Sheringham Shoal and Dudgeon Offshore Wind Farm Extension Projects

Main Construction Compound Targeted Consultation Responses

Title: Sheringham Shoal and Dudgeon Offshore Wind Farm Extension Projects Consultation Report Appendix 23 - Main Construction Compound Targeted Consultation Response Tables	
PINS document no.: 5.2.23.	
Document no.: C282-CC-Z-GA-00025	
Date:	Classification
August 2022	Final
Prepared by:	
Counter Context	
Approved by:	Date:
Jan Trønningsdal, Equinor	August 2022

Title:
Figure 3.3.1 Main Compound Alternatives
2. 1067 Fakenham Road, Attlebridge

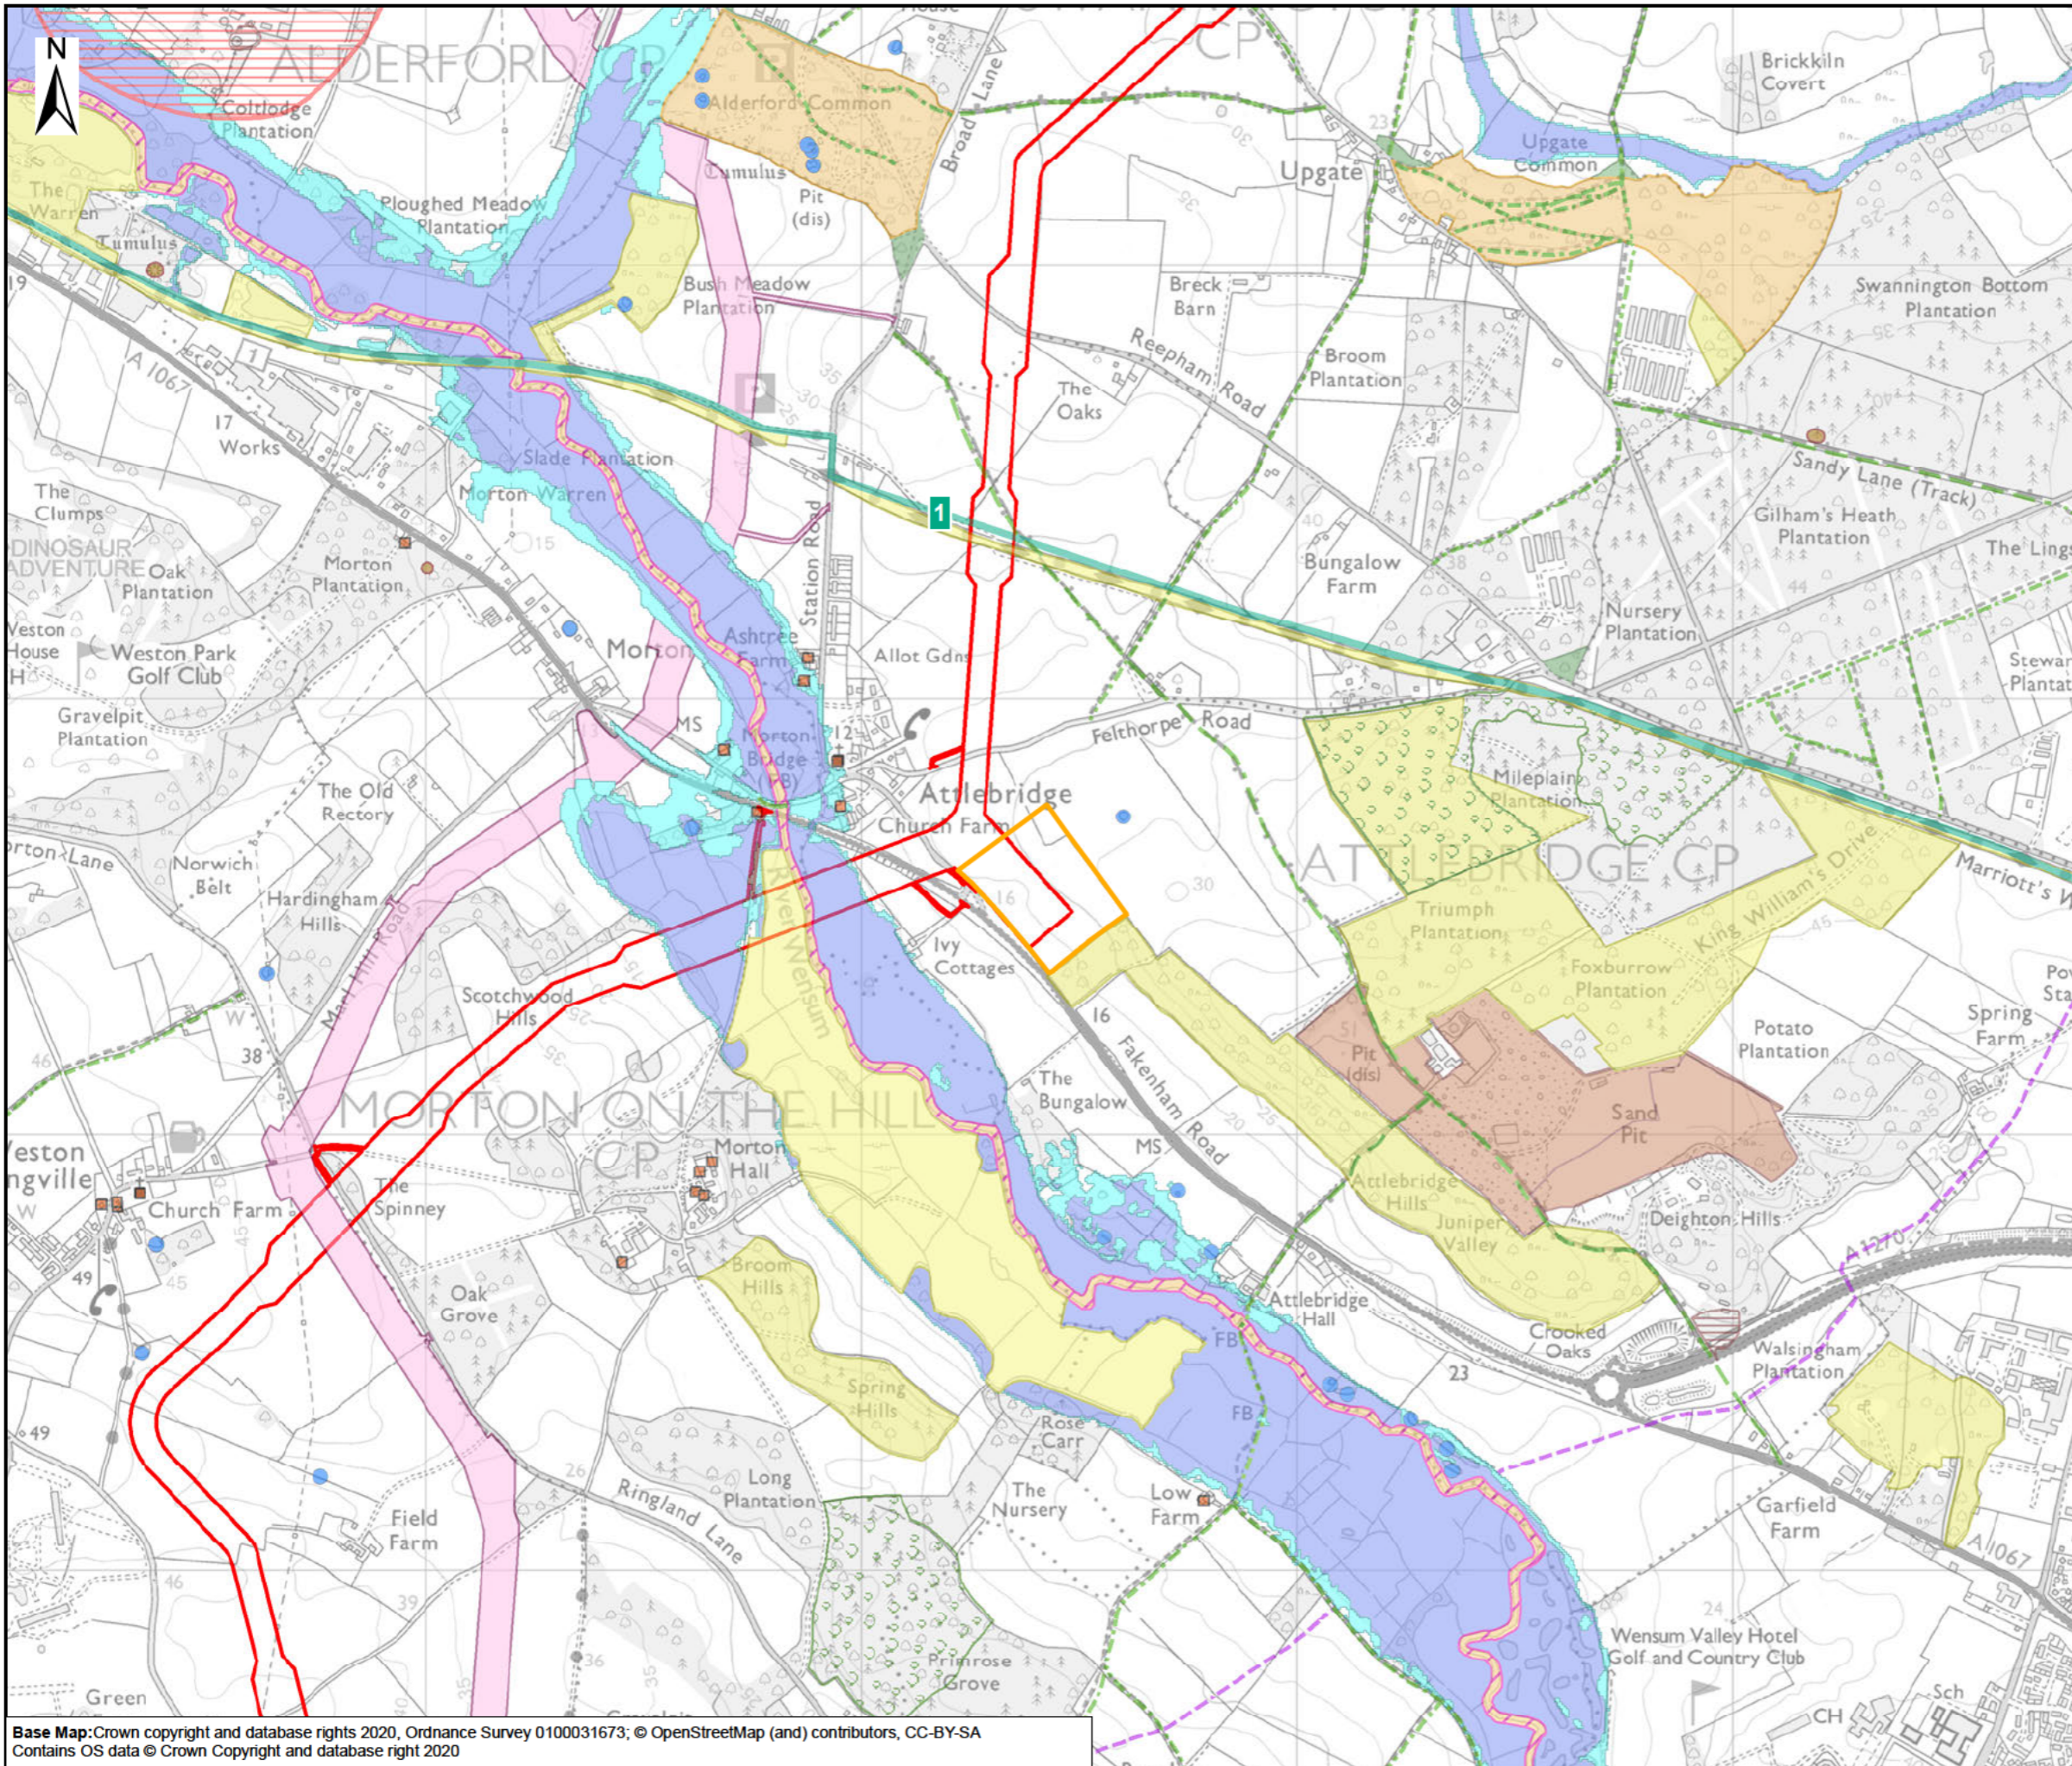
Jane Kenny on behalf of Mrs J Dacre	It is noted from the 'considerations', of the BRAG, it is whether the road is generally wide enough for 2 vehicles. Both roads are wide enough for two vehicles. The Old Fakenham Road which is the road off the A1067 is not wider enough to accommodate two-way HGV movements	N	The proposed location of the main compound is close to the junction with the A1067 where the width of Old Fakenham Road is wide enough to allow to HGVs to pass.
Jane Kenny on behalf of Mrs J Dacre	It is noted that further land may be required to ensure appropriate junction spacing. Landowners have been consulted in this regard.	N	The Applicant has developed an outline design for the proposed main compound access including the junction with the A1067. The design incorporates minor amendments to the junction geometry in the area. The

<p>Jane Kenny on Behalf of Mr J Riley & TM Trustees</p>	<p>It is noted that further land may be required to ensure appropriate junction spacing. Landowners have been consulted in this regard.</p>	<p>N</p>	<p>The Applicant has developed an outline design for the proposed main compound access including the junction with the A1067. The design incorporates minor amendments to the junction geometry in the area. The Applicant is confident the access and any associated amendments to public highway can be accommodated within the order limits and existing public highway. The Applicant can confirm that all landowners in this area have been consulted. Following our land referencing and due diligence checks all identified parties have been consulted with. The design of the main compound access and junction with the A1067 has been checked using swept path</p>

Applicant is confident the access and any associated amendments to public highway can be accommodated within the order limits and existing public highway. The Applicant can confirm that all landowners in this area have been consulted. Following our land referencing and due diligence checks all identified parties have been consulted with.

The design of the main compound access and junction with the A1067 has been checked using swept path analysis software (which simulates the path that would be taken by vehicles). The outline design and swept path analysis drawings have been shared with Norfolk County Council (NCC) as the local highway authority, and NCC have provided in principle support for the proposed access designs. Final details of the proposed access design and amendments to the junction with the A1067 are included within the Transport Assessment which is Appendix 24.1 of **ES Chapter 24 Traffic and Transport** (Document reference : 6.1.24)..

Title:
Figure 3.3.1 Main Compound Alternatives
8. A1067 Norwich Road

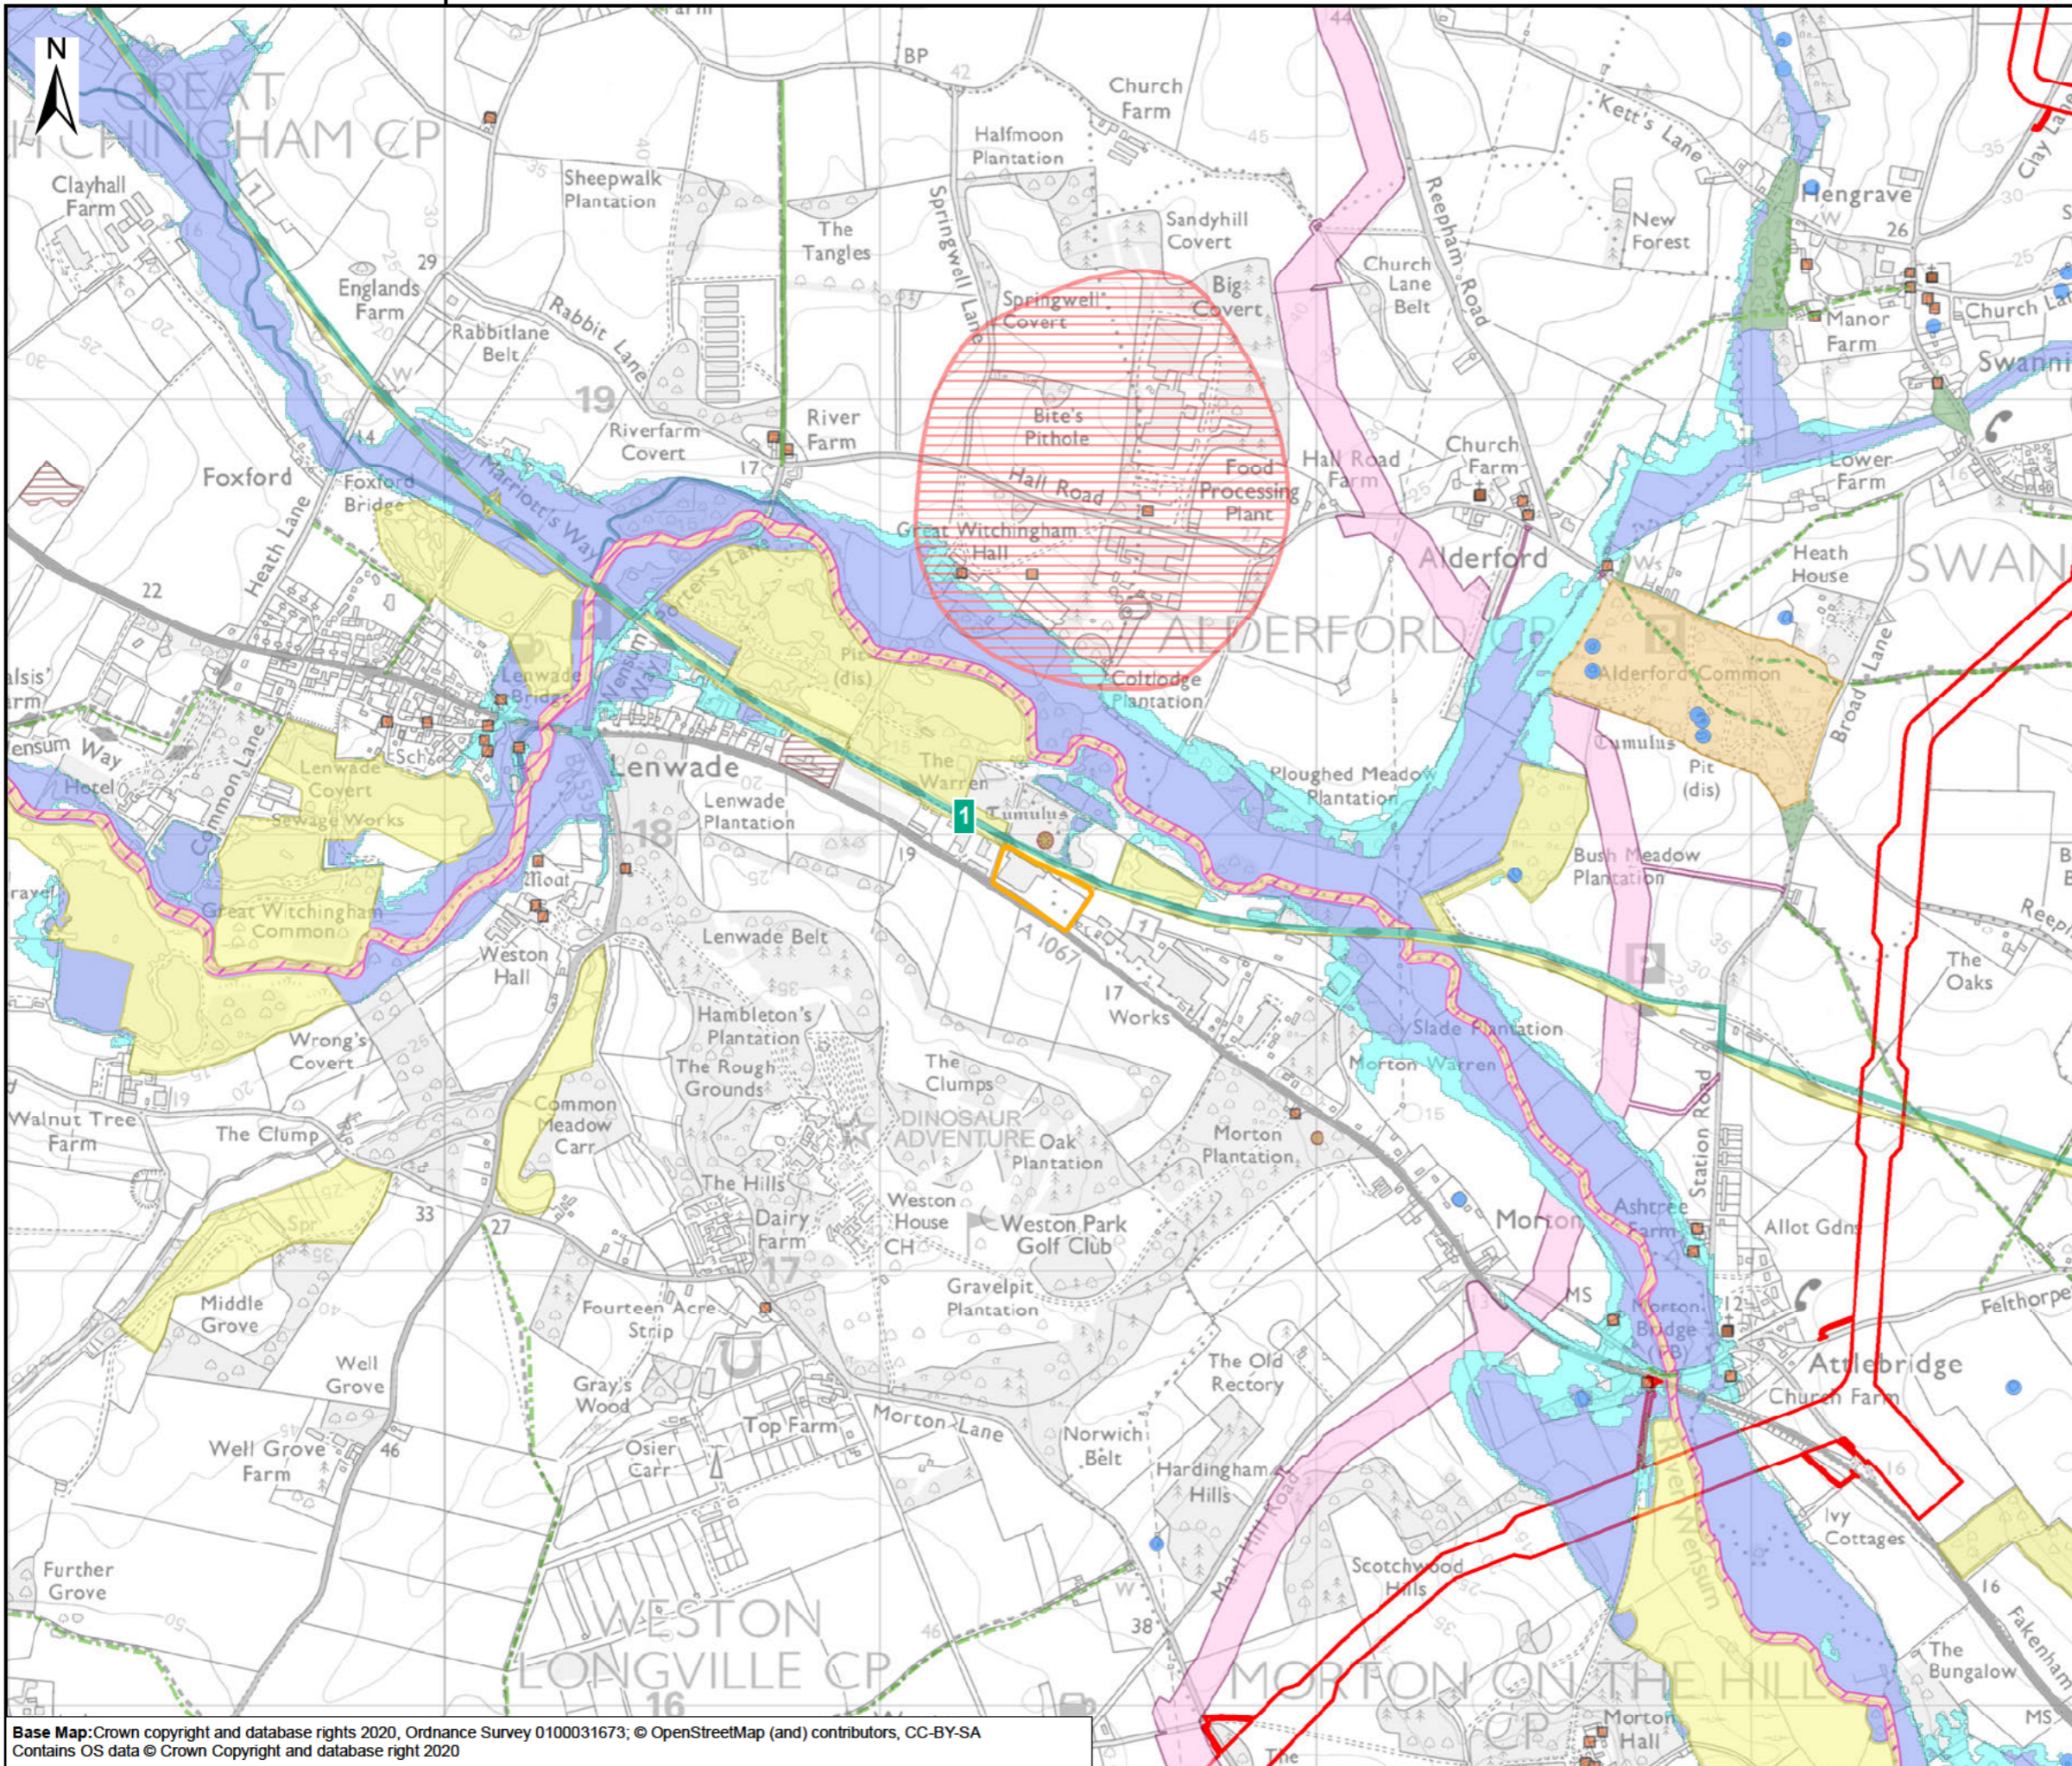
Norfolk County Council	the County Council couldn't find a plan to show the size of the land at A1067 Norwich Road required in contrast to the size of land available.	N	Maps showing the potential compound locations including the site at A1067 Norwich Road can be found in the appendix of the Onshore Compound Site Selection Report (document reference 6.3.3.3)

Norfolk County Council	A significant part of the site at A1067 Norwich Road has existing warehouses which it is claimed would not be suitable for the proposed cable drum storage. It has not been made clear why the use of the warehouses is not suitable.	N	The existing warehouses were surveyed and were not considered suitable for use for the SEP and DEP works due to the layout and sizes of the buildings. Whilst the warehouses could be excluded from the working area, the presence of extensive asbestos contamination in proximity to the working area would represent a significant health and safety risk.
Norfolk County Council	The required visibility splays will impact on hedges and require hedgerow removal. This isn't shown on the submitted plans and it is recommended the District Council/Landscaping Officers satisfy themselves that any such impact is acceptable from a landscape perspective.	N	An updated drawing showing the swept path analysis is included within the Transport Assessment which is Appendix 24.1 of ES Chapter 24 Traffic and Transport (Document reference : 6.1.24).
